Immingham Eastern RO-RO Terminal
TR030007
Natural England
Principal Areas of Disagreement Summary
Statement (PADSS)
Finalised: 15.08.23

**THE DISTRIBUTION OF COASTAL  
WATERBIRDS WITHIN SECTOR B**

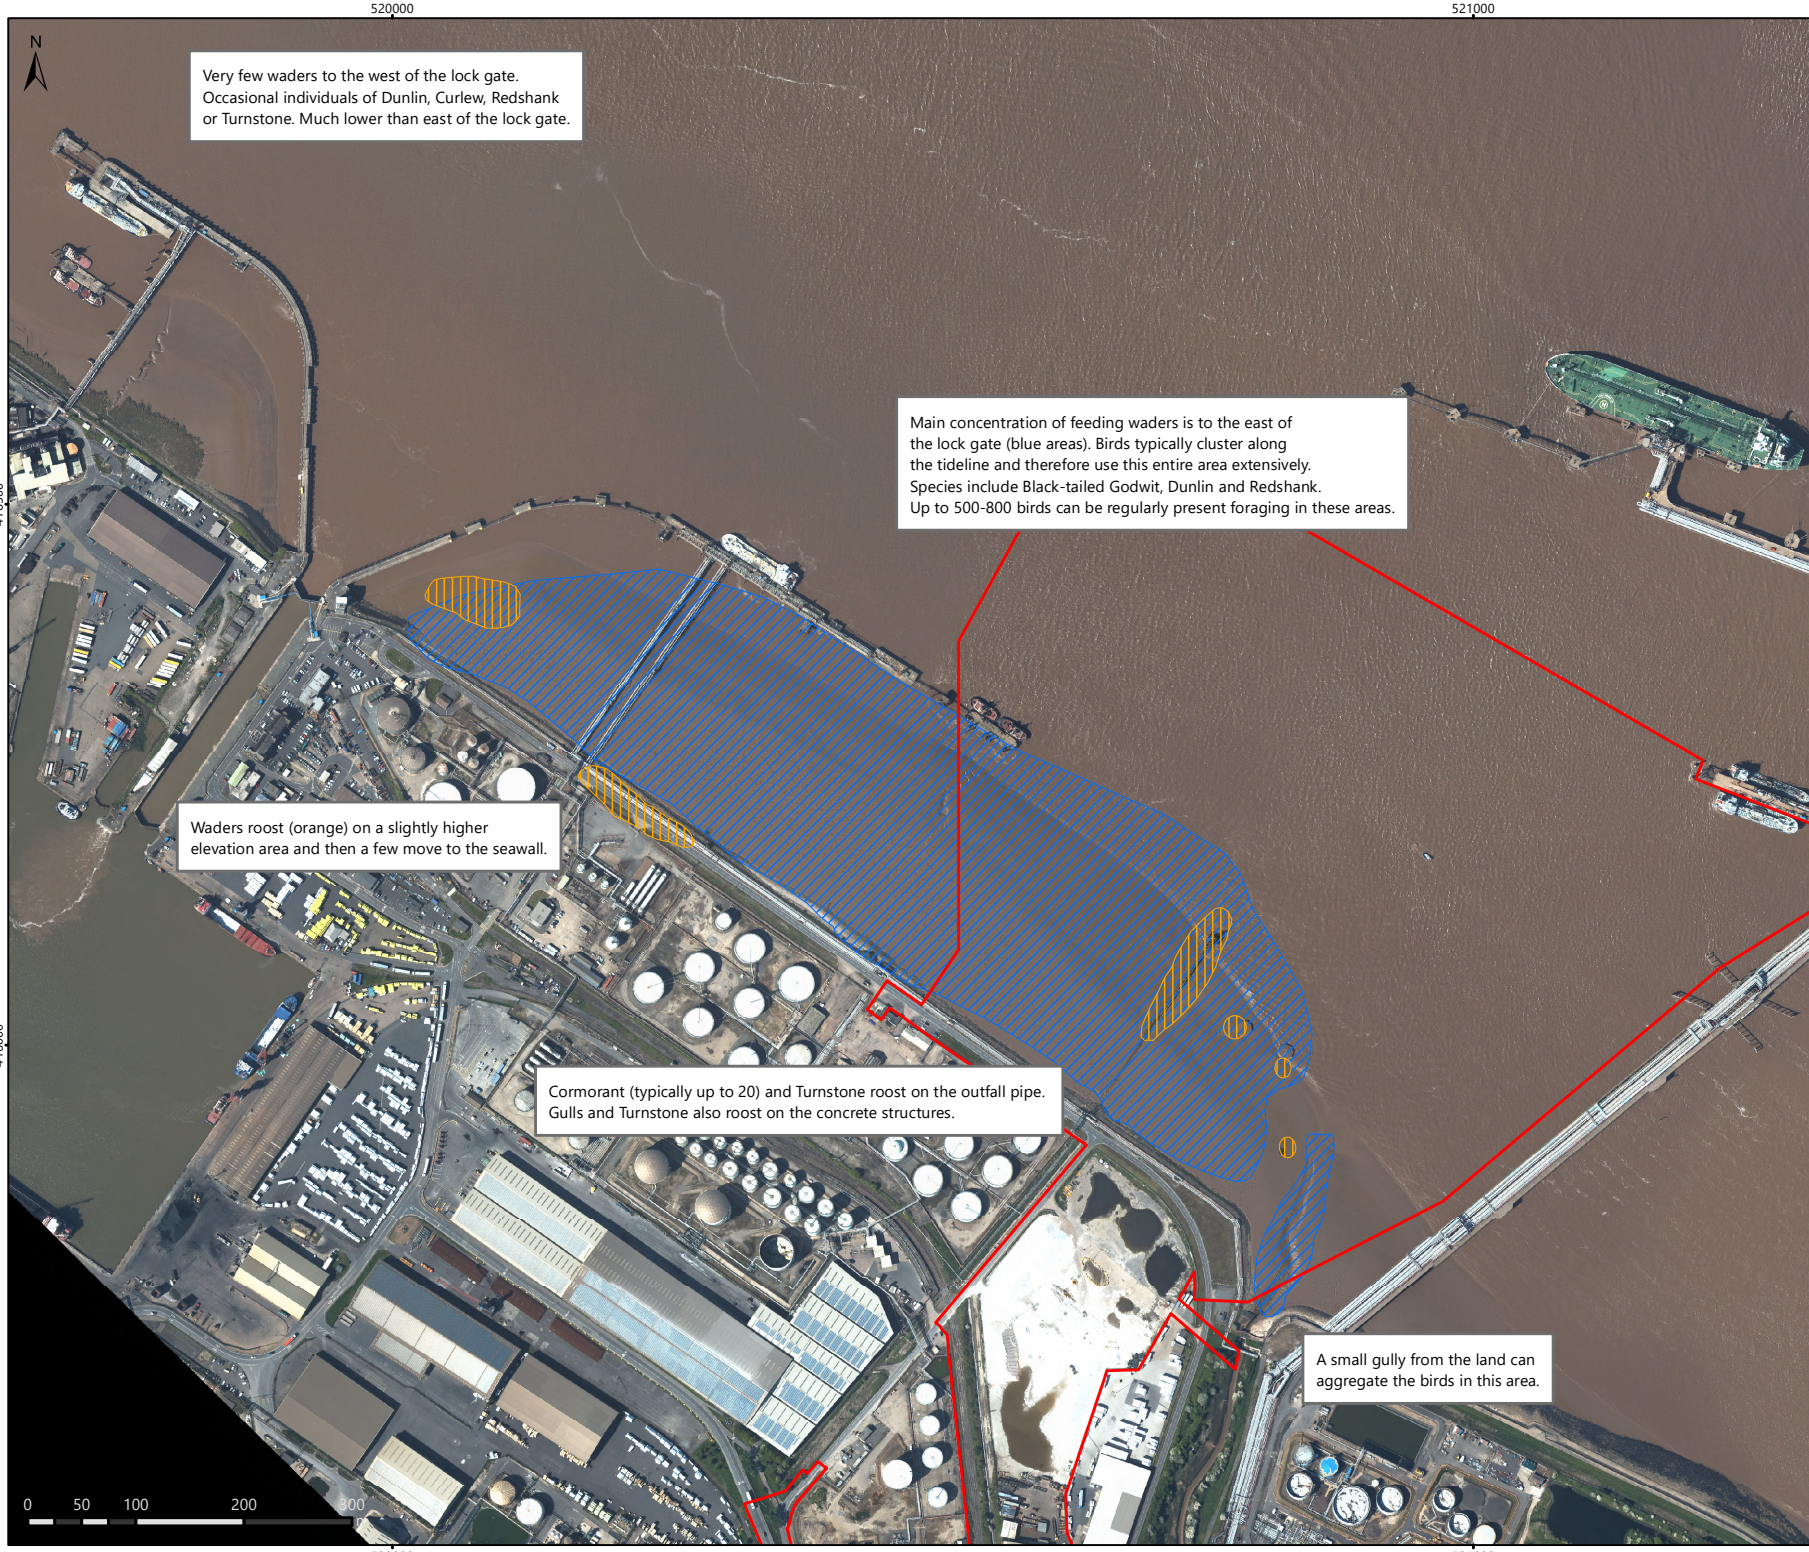
| Ref | Area of disagreement | Summary of concern held by Natural England | What needs to change, or be included or amended to overcome the disagreement? | Likelihood of the concern being addressed prior to submission of the application/ during the Examination |
|-----|--|---|---|--|
| 1. | Potential changes in waterbird foraging and roosting due to operation (presence of infrastructure) | <p>We are concerned that SPA waterbirds will be displaced from the intertidal habitat in the area between the new approach jetty and the Immingham Oil Terminal and for 20m beyond the new jetty once constructed. The 2 jetties will effectively 'enclose' an area of mudflat including the outfall channel. Our current view is that this will lead to loss of functional habitat for a range of SPA waterbirds during the operational period.</p> <p>We are particularly concerned about impacts on black tailed godwit as they occur in numbers over 10% of the estuary population in sector B of the Immingham frontage. In addition black tailed godwit numbers in the Humber Estuary are declining and this is considered to be due to site specific pressures rather than more widespread issues (according to WeBS bird alerts). We therefore advise taking a precautionary approach to the assessment of loss of foraging and roosting habitat.</p> | <p>More detailed assessment of impact of loss of functional habitat for SPA waterbirds.</p> <p>Assessment of loss of habitat for SPA birds should include assessment of loss compared to the available habitat used by the species on the Humber Estuary (not all mudflat).</p> | Likely |

**CONSTRUCTION ACTIVITY ASSOCIATED WITH  
THE APPROACH JETTY AND INNER PIER AND  
POTENTIAL DISTURBANCE ZONE BUFFER**

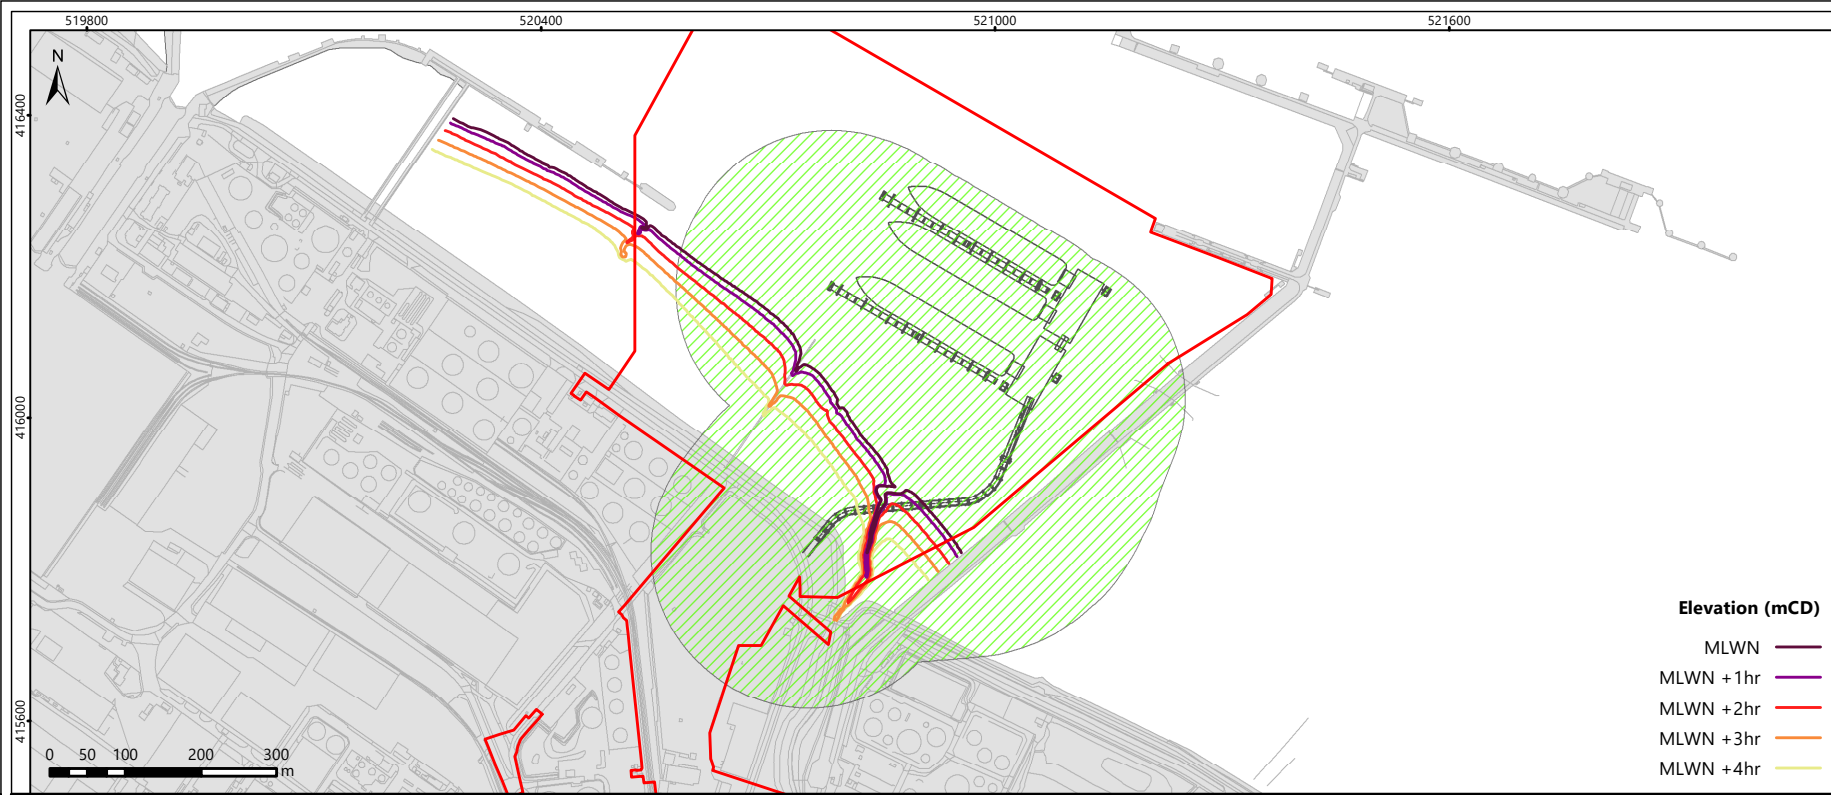
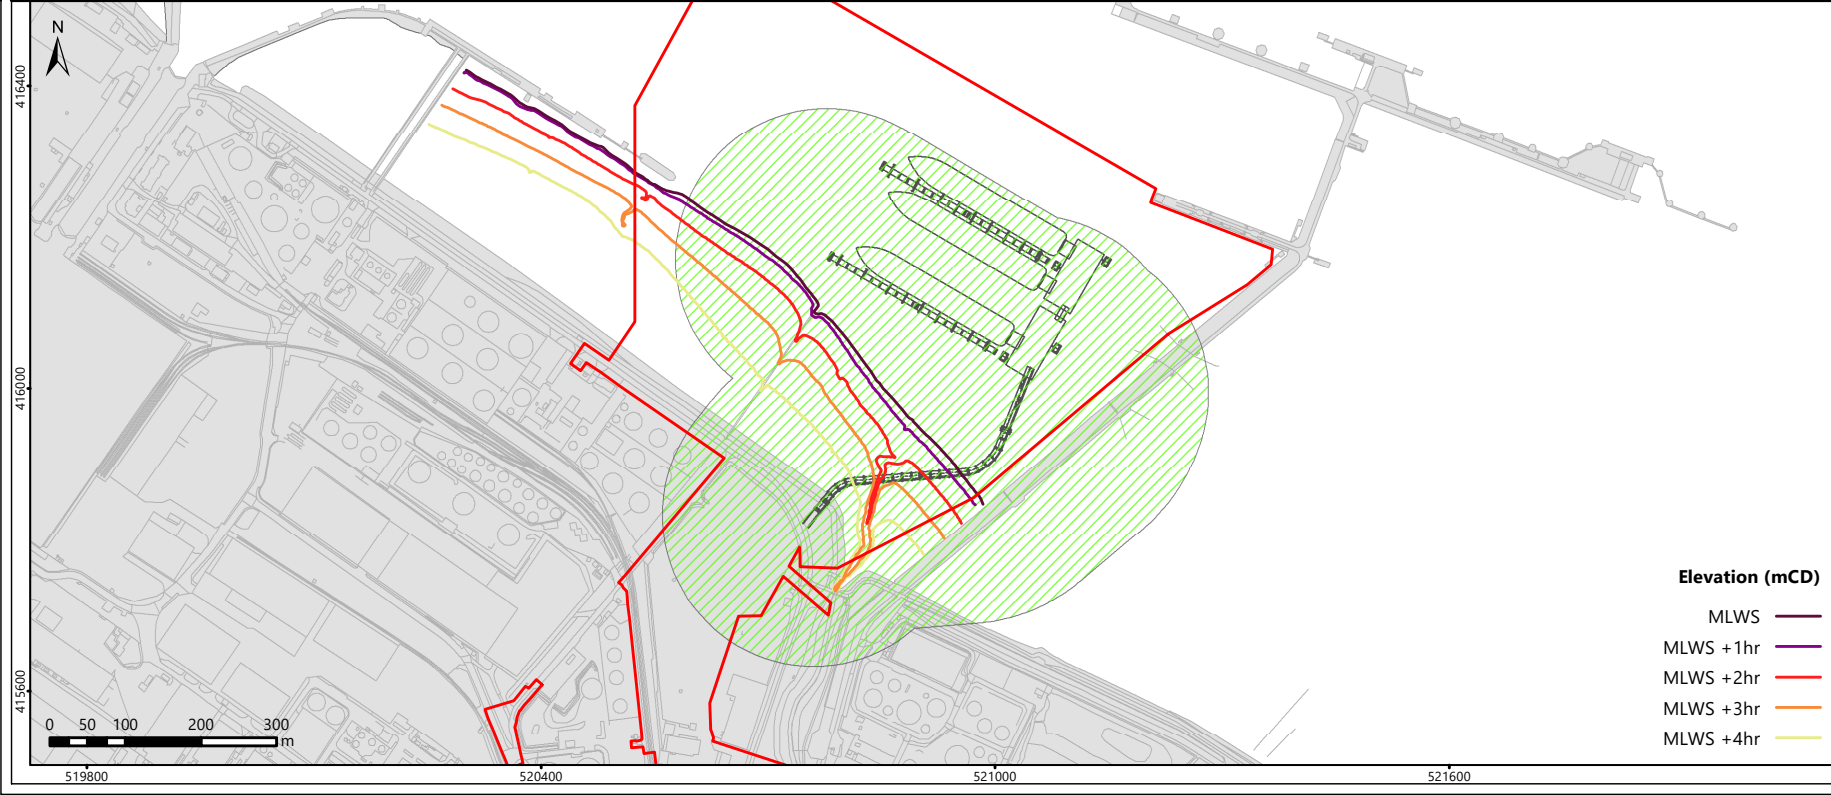
| 3. | Use of 200m rather than 300m as disturbance distance for SPA waterbird species. | ABP's HRA information (table 27) shows that some SPA waterbird species show flight initiation distances over 300m, including key species including shelduck. There is limited data for black tailed godwit. It is not therefore clear why 200m has been used in assessments and mitigation measures. | We advise taking a precautionary approach, using 300m as the disturbance distance in assessments and mitigation measures. | Likely |
